Please ask for: Ms Iqraa Malik
Email: iqraa.malik@terraquest.co.uk
Telephone: 0121 234 1390
Our Ref: EP/37/22/HH
Your Ref:
Date: 31st March 2022

Application for Planning Permission for Works or Extension to a Dwelling

Development: Erection of single storey rear extension with new raised patio following demolition of existing conservatory.
Location: 11 Willowhayne Crescent East Preston BN16 1PJ

Proposed Site Plan
Scale 1:200 @ A1

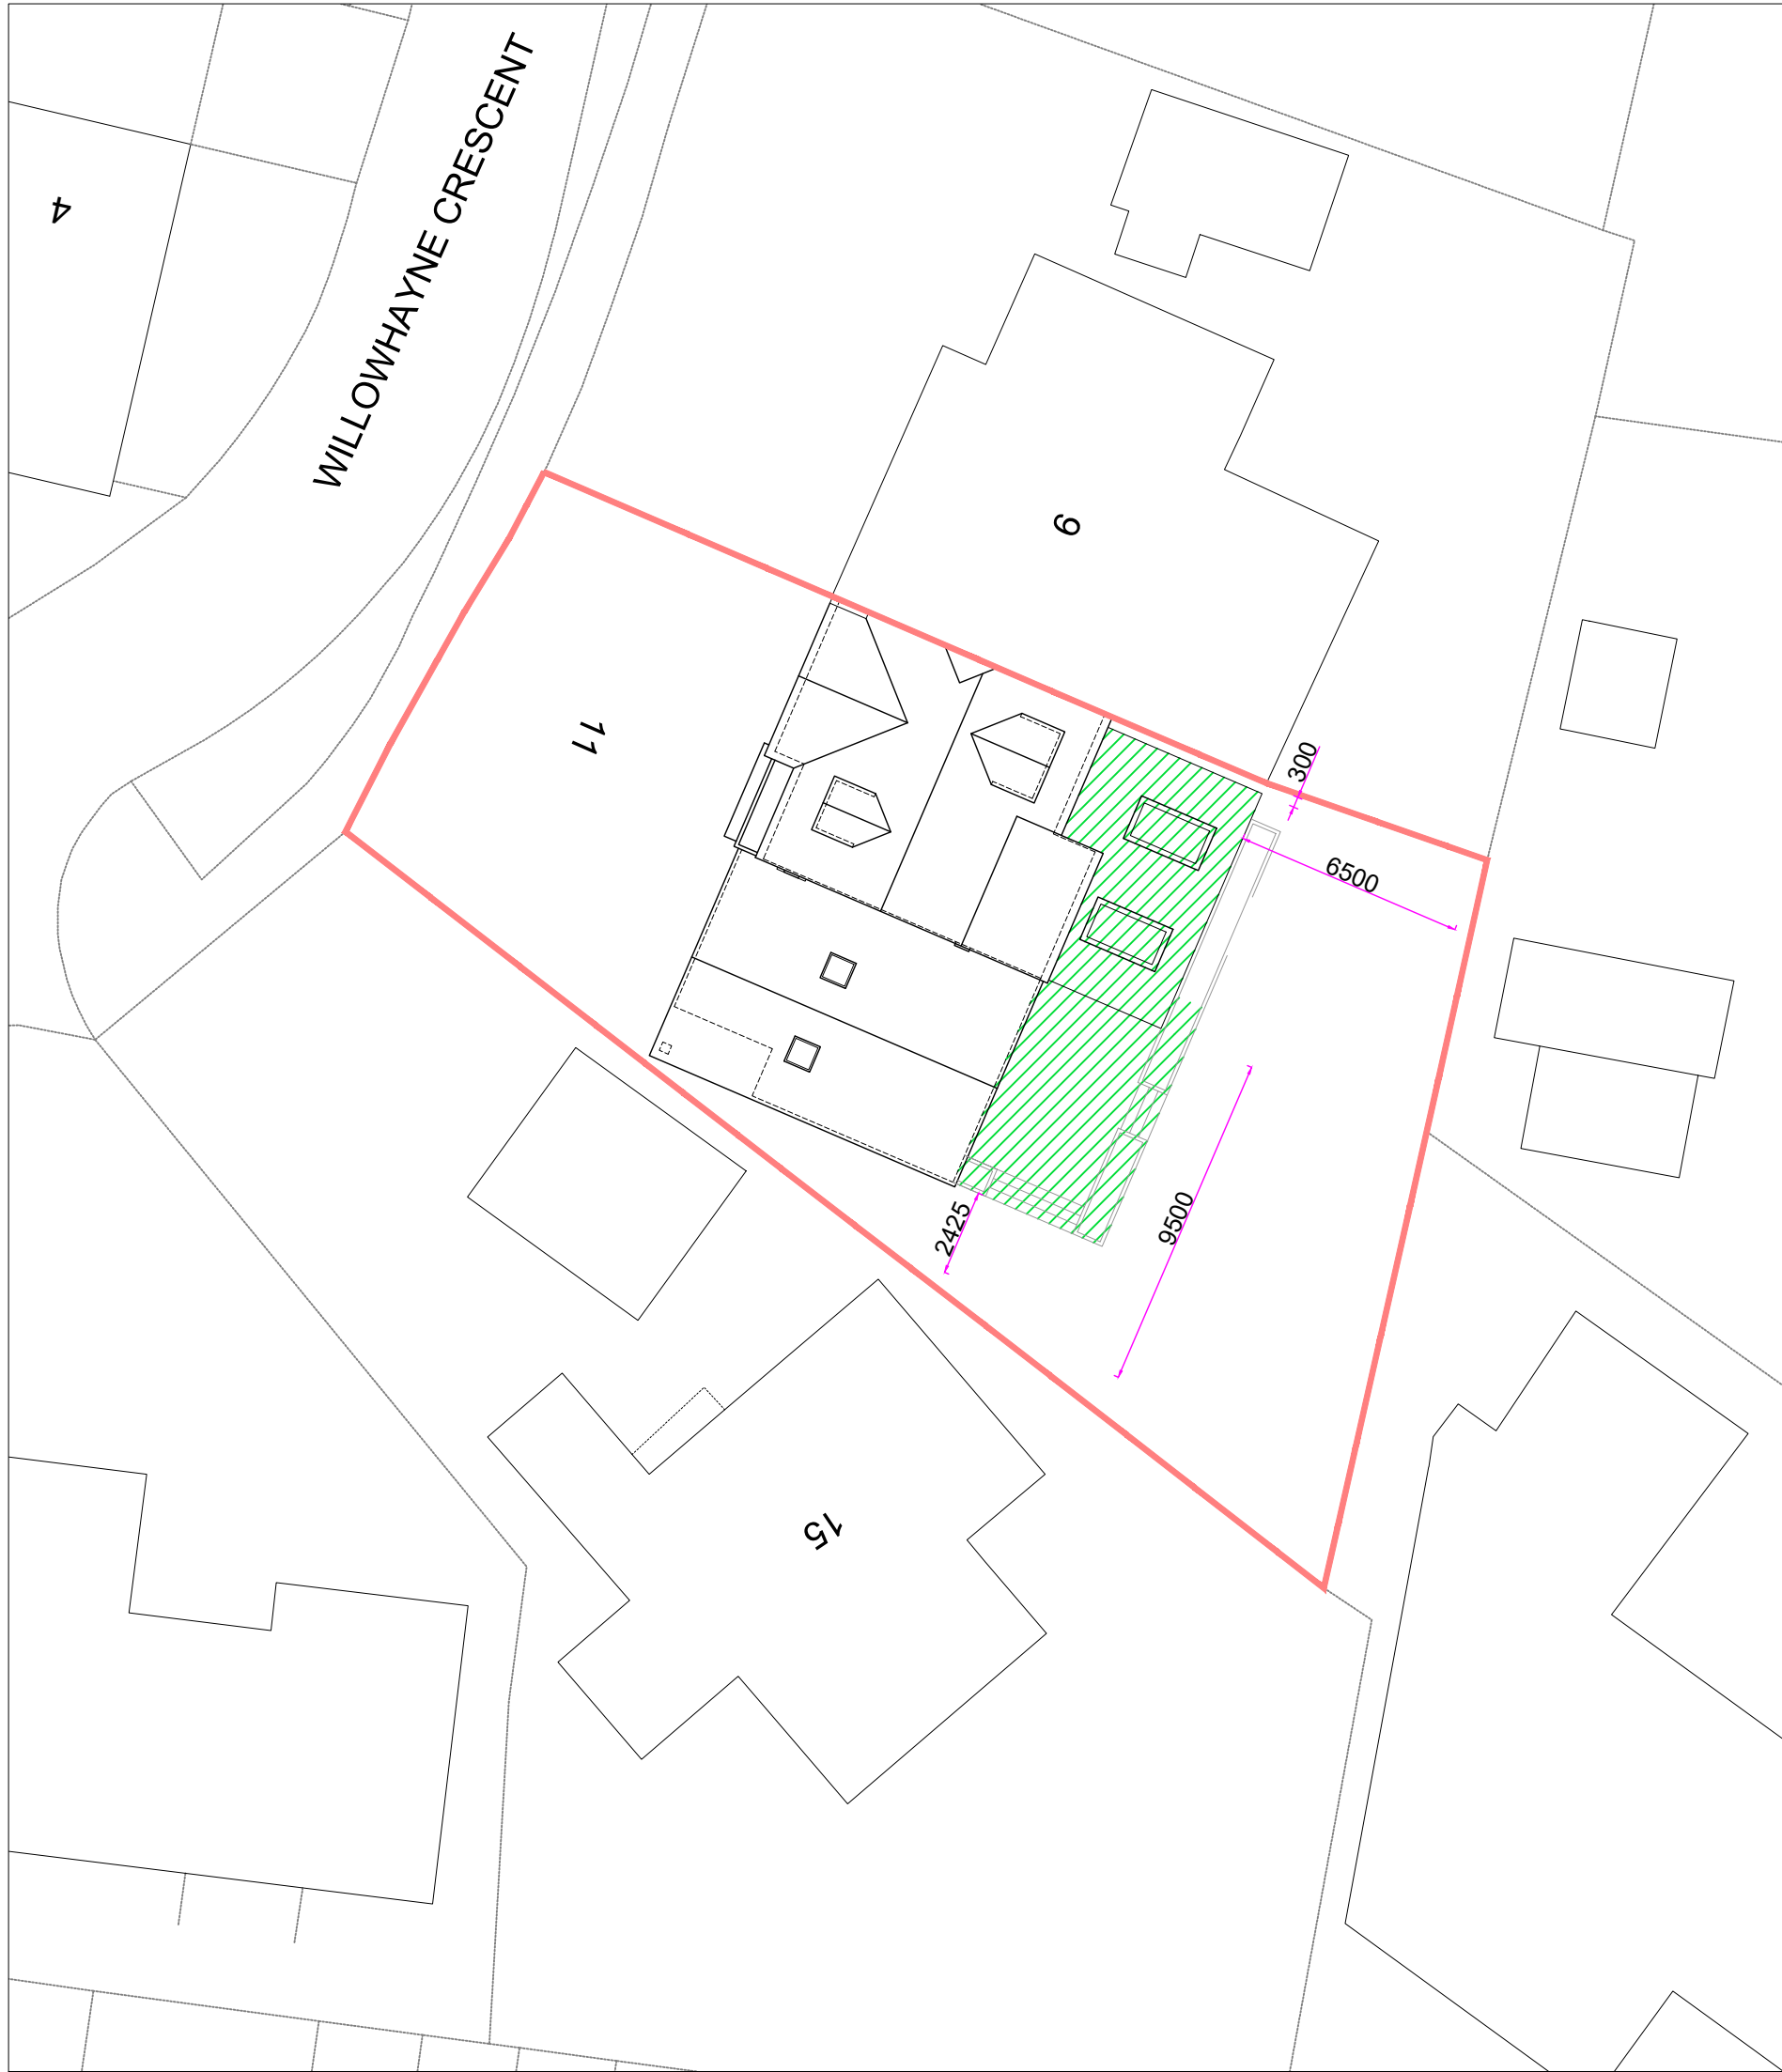
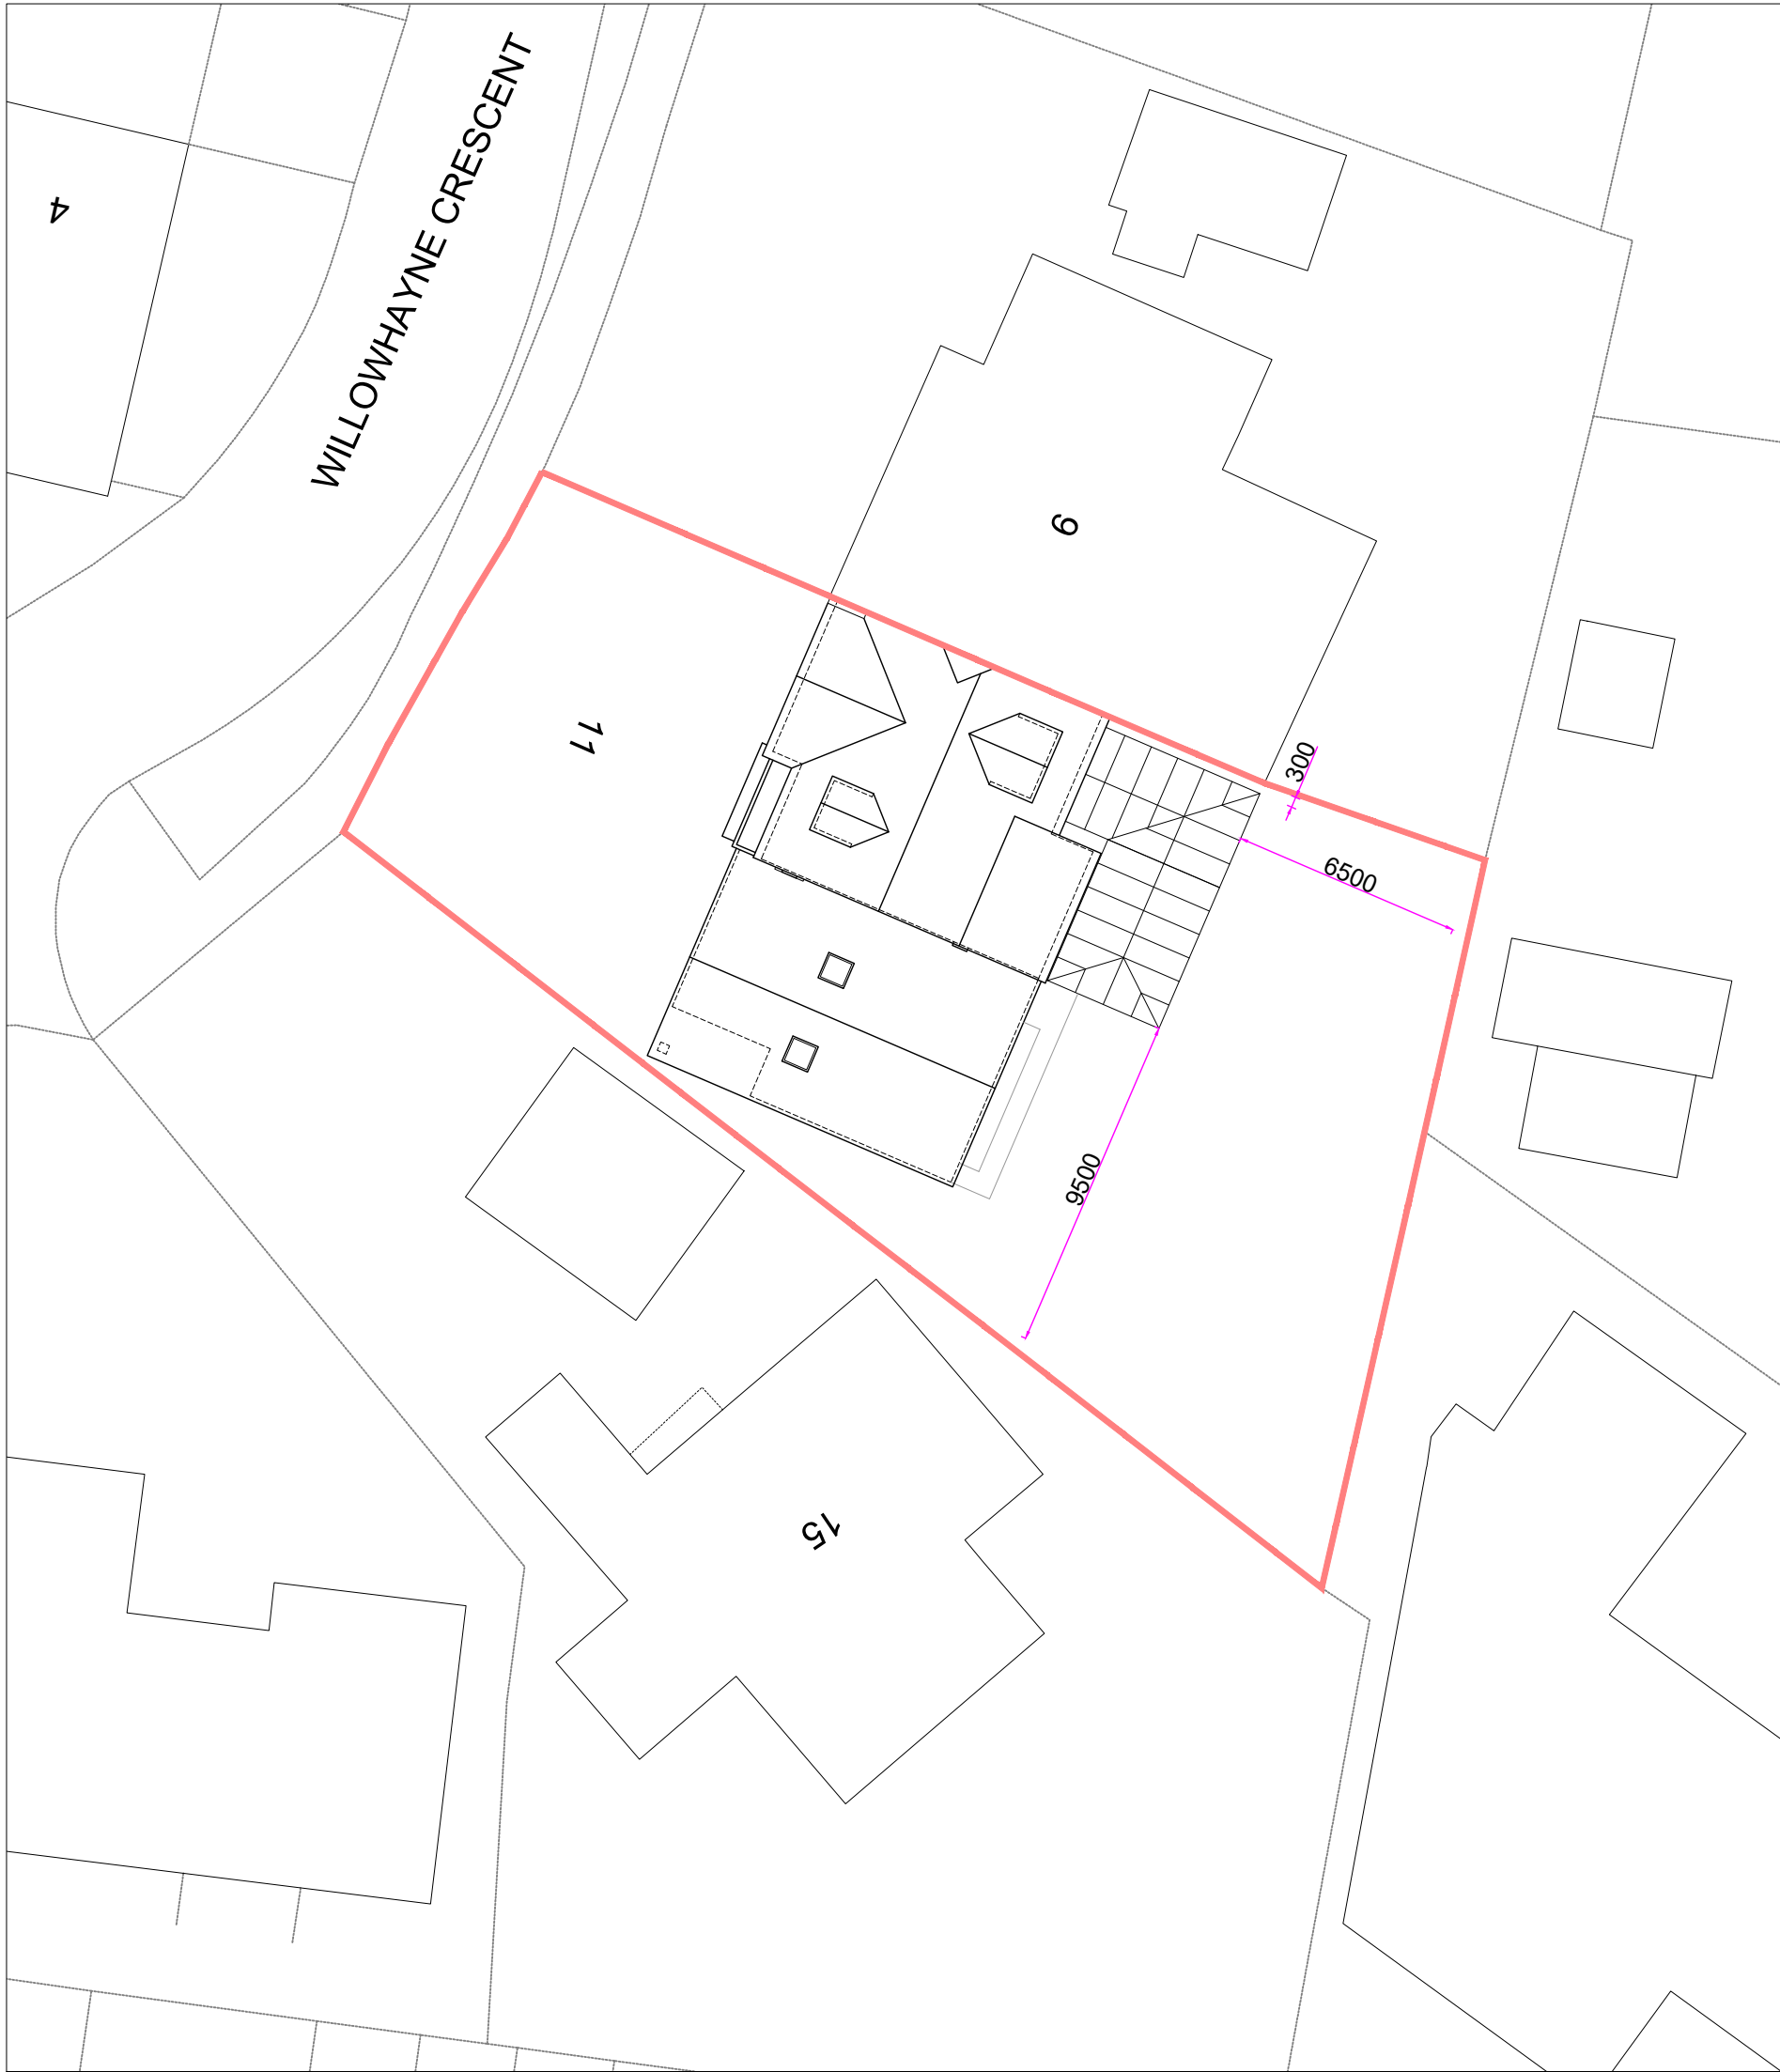
Block Plan

You are required to have dimensions from the proposed extension(s) to all site boundaries. Please amend.
